From: [Connor Smalls](#)
To: [PScan1](#)
Subject: Fw: 22/01559/F The Maltings, Tower Road, Burnham Overy Staithe.
Date: 14 October 2022 09:29:20
Attachments: [2022.10.13_MLT_Response_to_planning_comments.pdf](#)
[2021.10.13_MLT_pp_04_IssueRegister.pdf](#)
[2022.10.13_MLT_pp_04_Drawings.pdf](#)
[Outlook-zqc4b1kb.png](#)

Subject: 22/01559/F The Maltings, Tower Road, Burnham Overy Staithe.

Dwg: 1.11
Rev: 03

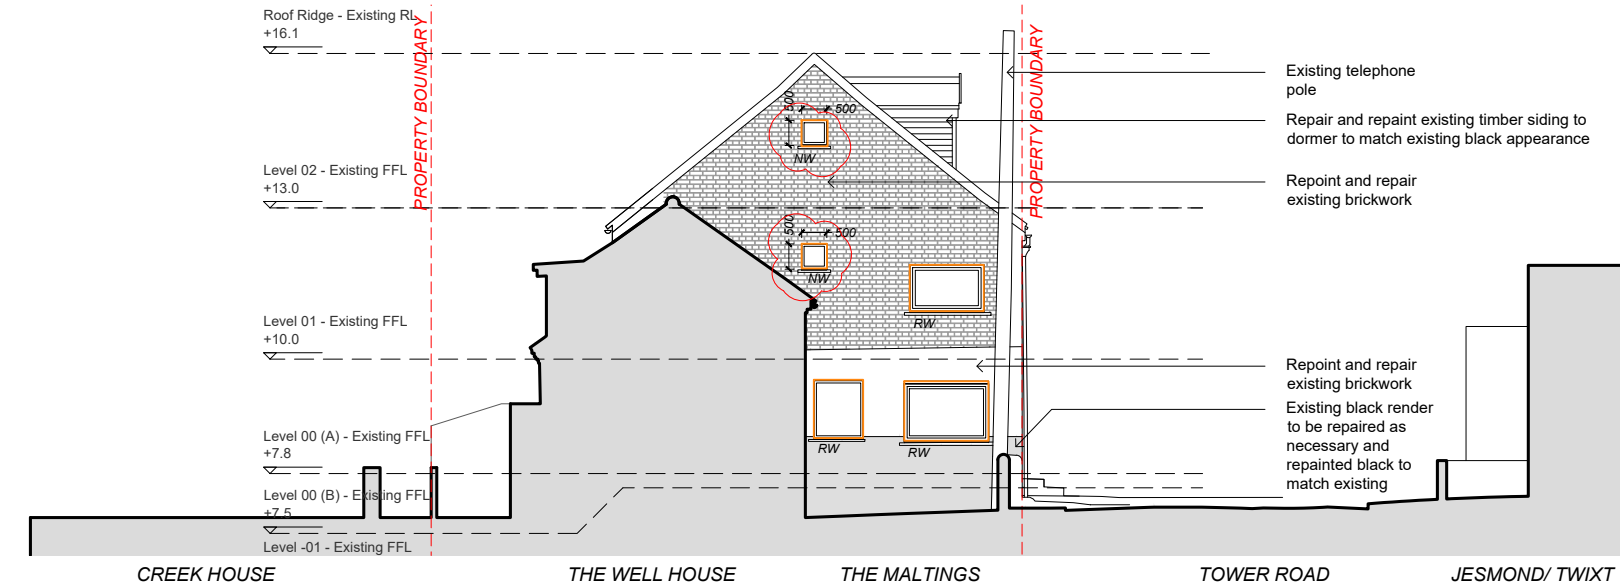
Steven: The high level windows on the North Facade have been re-sized and re-arranged. The two new windows on the West Facade have also been resized and aligned. There have also been some adjustments to the arrangement and quantity of conservation roof lights. As the parking will remain largely as is, the garden wall will also remain largely as is however with the opening increased to accommodate a larger vehicle.
